LIME DOWN SOLAR PROJECT

DEADLINE 4 COMMENTS STOP LIME DOWN

July 2026

APFP Regulation: 5(2)(a)
Application Doc No.: APP/6.2
Drawing no.: 14-3

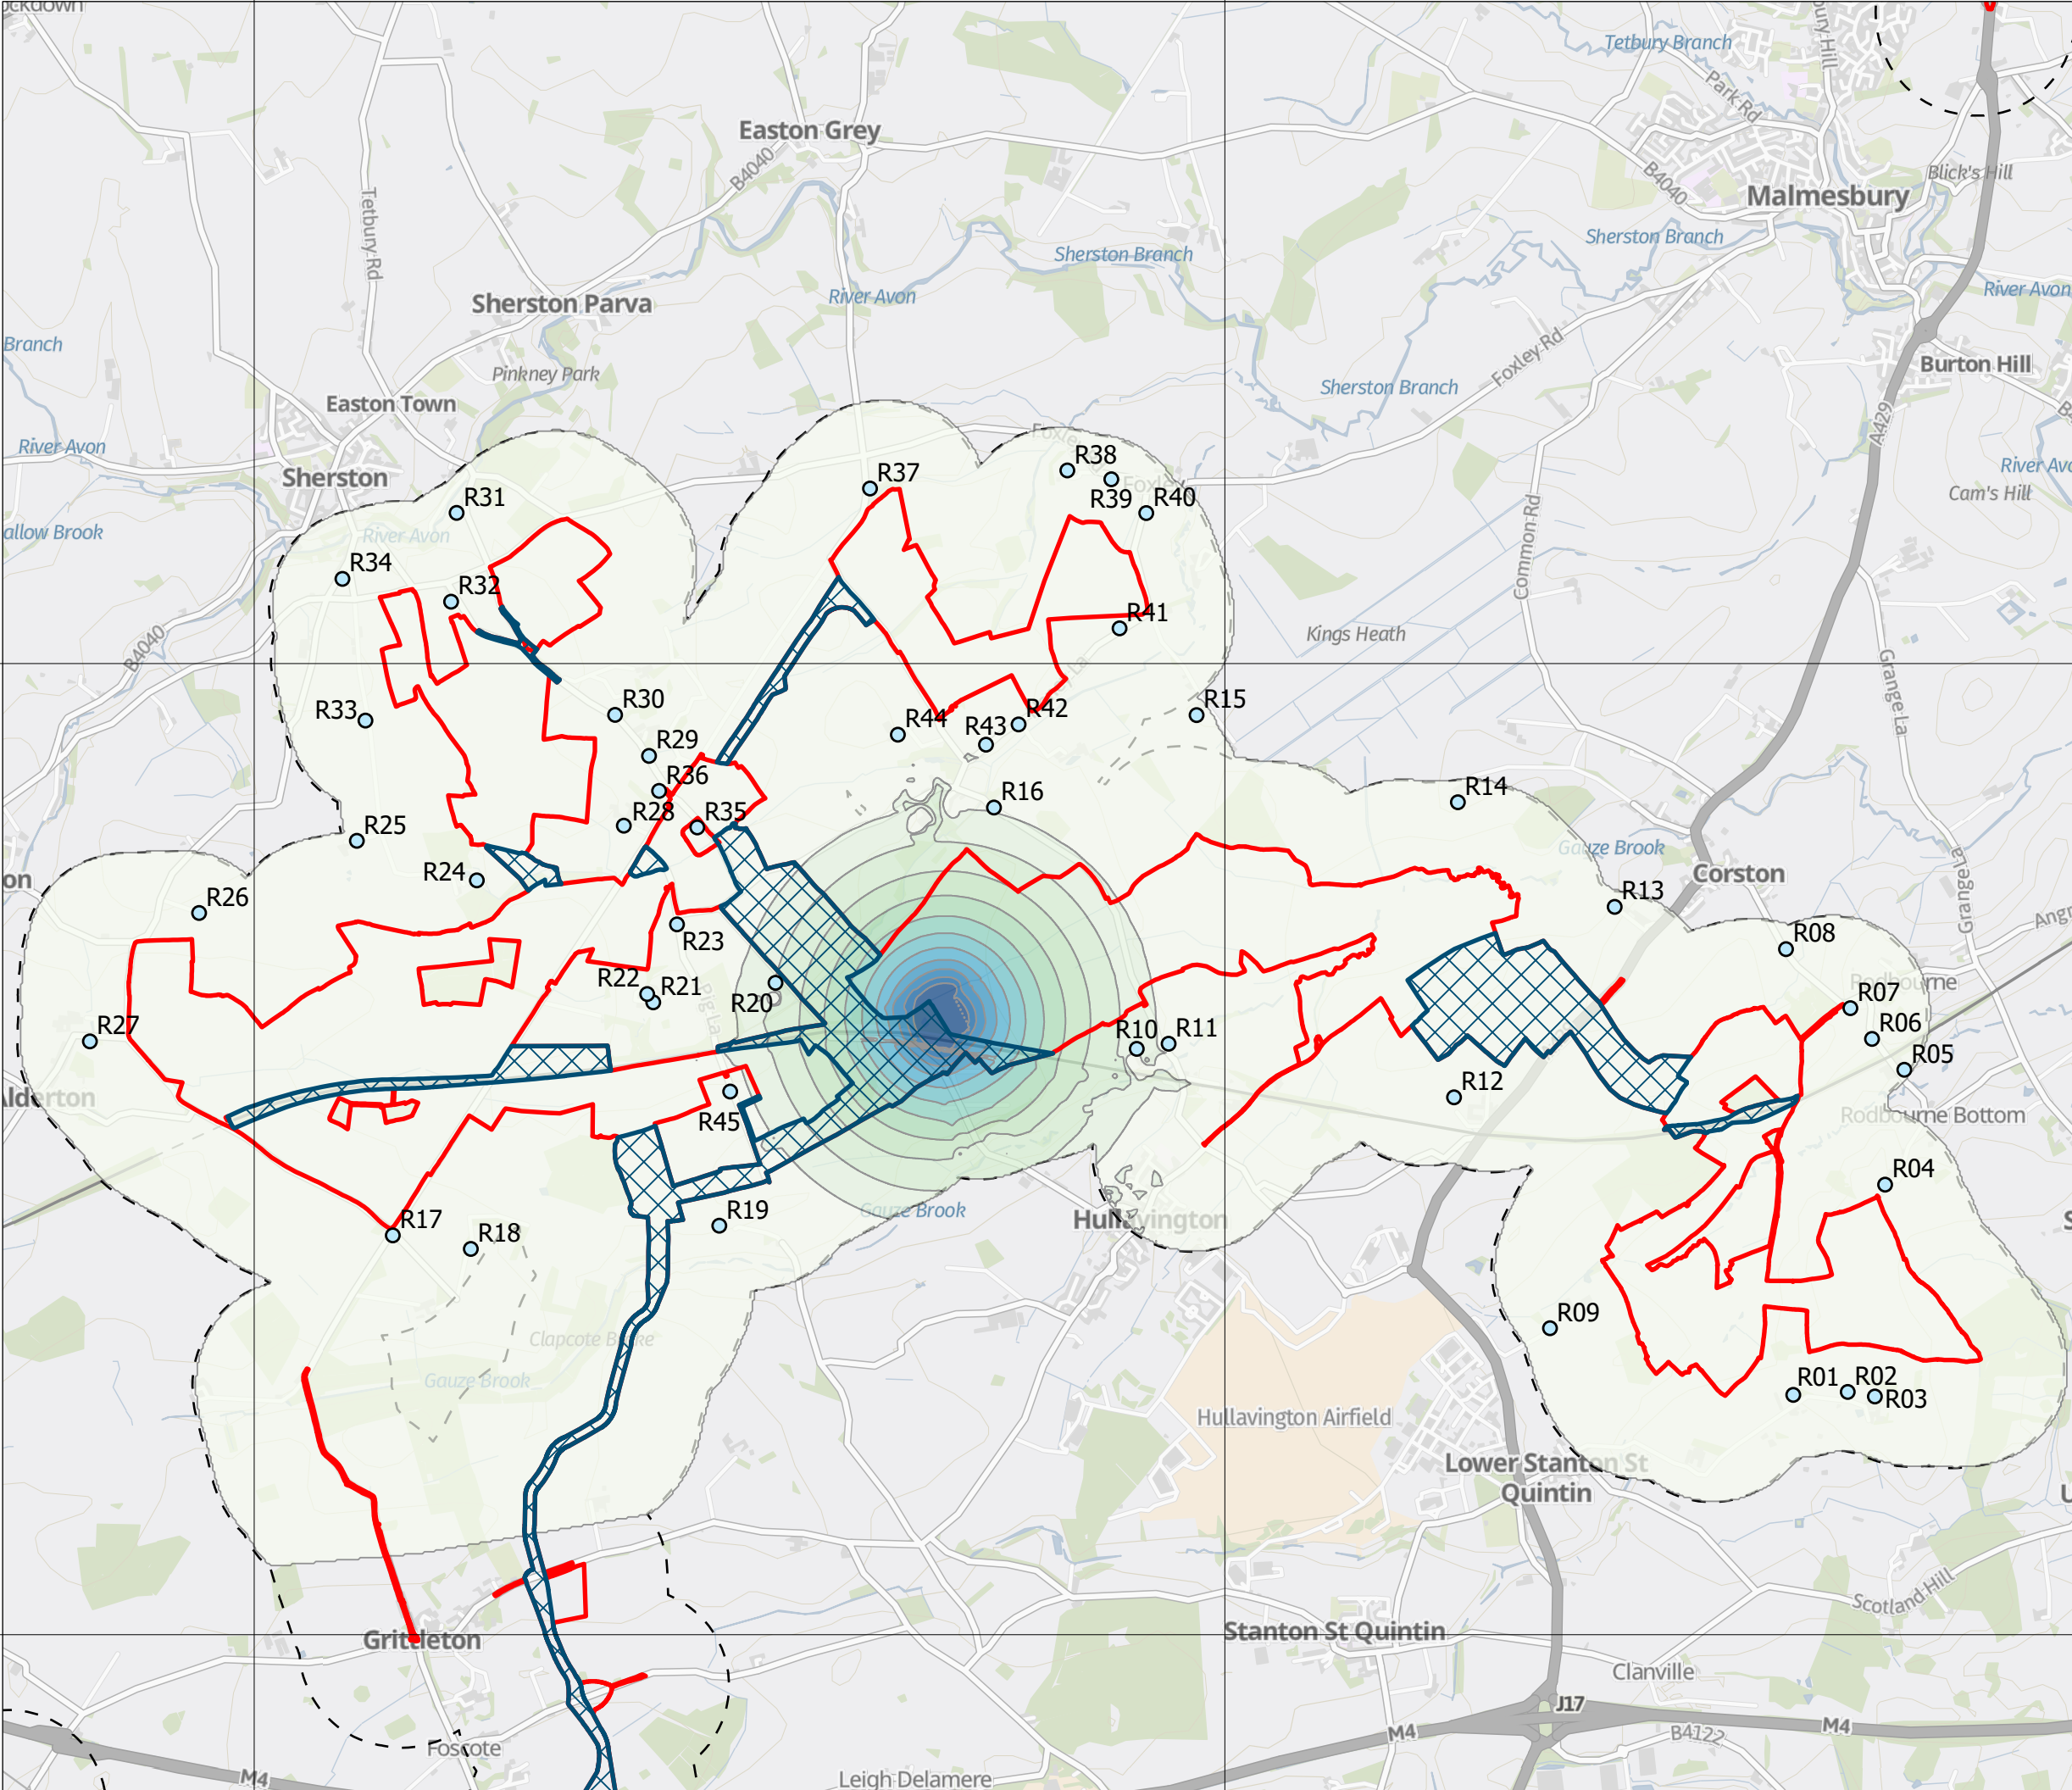
faces audible electrical noise in the region of 50dB. Then, joining an ancient Roman Road connecting parts of the CNL; a key heritage asset the Applicant has underassessed the significance of and the effects on.
